# Consultee Comment for planning application 6/2019/0085/MAJ

<b>Application Number</b>	<input type="text" value="6/2019/0085/MAJ"/>
<b>Location</b>	<input type="text" value="Chancellors School, Pine Grove, Brookmans Park, Hatfield, AL9 7BN"/>
<b>Proposal</b>	<input type="text" value="Erection of building comprising sports hall with associated changing facilities and 7 x classrooms built on existing hard play tennis courts; 4 x hard play sports pitches to be provided to replace existing; provision of 33 x parking spaces; and two mobile classrooms to be provided for the duration of the project"/>
<b>Case Officer</b>	<input type="text" value="Mr David Elmore"/>
<b>Organisation</b>	<input type="text" value="Welwyn Hatfield Borough Council"/>
<b>Name</b>	<input type="text" value="Parking Services"/>
<b>Address</b>	<input type="text" value="Council Offices The Campus Welwyn Garden City Herts AL8 6AE"/>
<b>Type of Comment</b>	<input type="text" value="Comment"/>

Drawing Title
 SURFACE WATER DRAINAGE STRATEGY
 EXISTING AND PROPOSED
 IMPERMEABLE AREAS

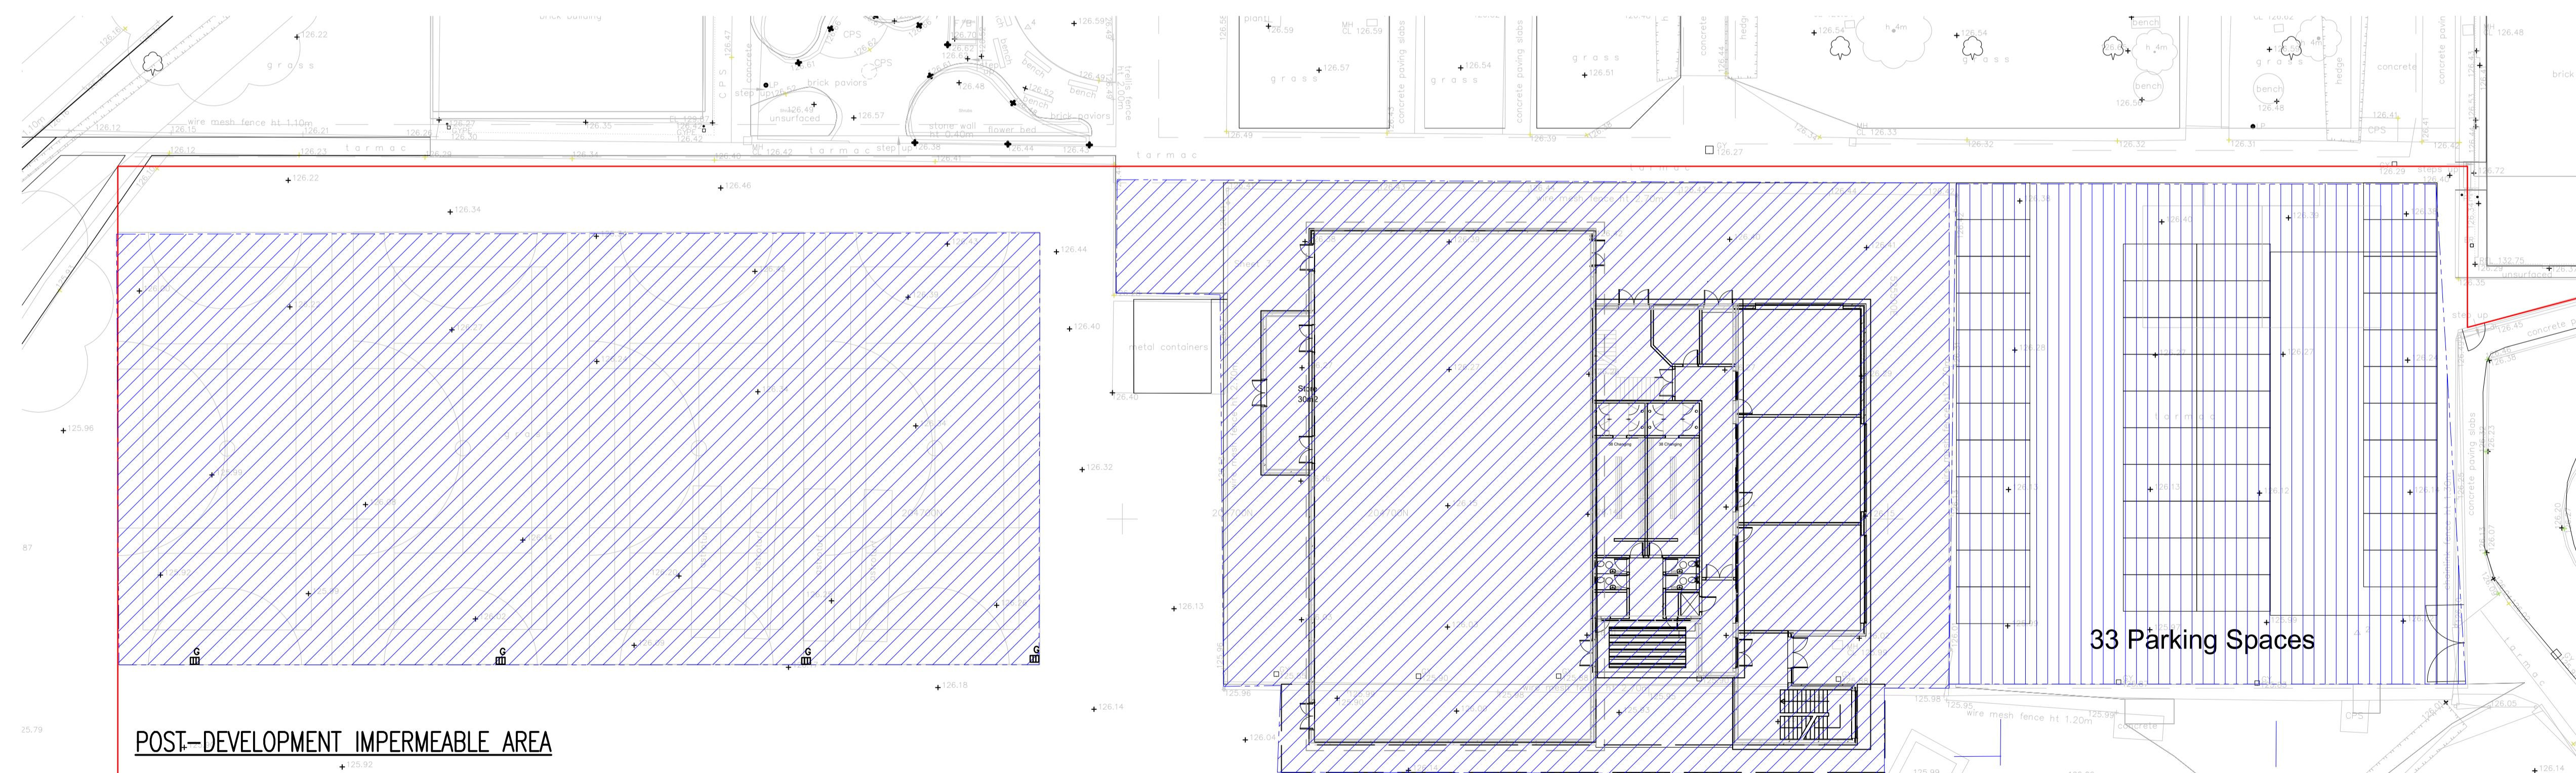
<b>Type</b>	<input type="text"/>
<b>Comments</b>	<input type="text" value="Looking through the documentation I can see that the proposal is to provide an additional 33 parking spaces on the current hard court, this will not be available until at least September 2020. There will have been at least one additional intake of 30 pupils, I appreciate that a drop off point will be created to provide 7 spaces but it isn't clear when this will be made available. Currently there is parking congestion at drop off and pick up times and I fell this will be exacerbated if the school number were to increase. The Council receive reports of parents parking/waiting on yellow lines during the days and times they operate and this can cause obstruction. The Parking Enforcement team are not able to be at all schools at all times. As the children get older and inevitably the get a car, what measures will be put in place to prevent as so is practicable the children bringing them to school? I also note that discussions are taking place to look at traffic calming measure in Pine Grove and the school access road and I would be interested to know what the outcome of those discussions are."/>
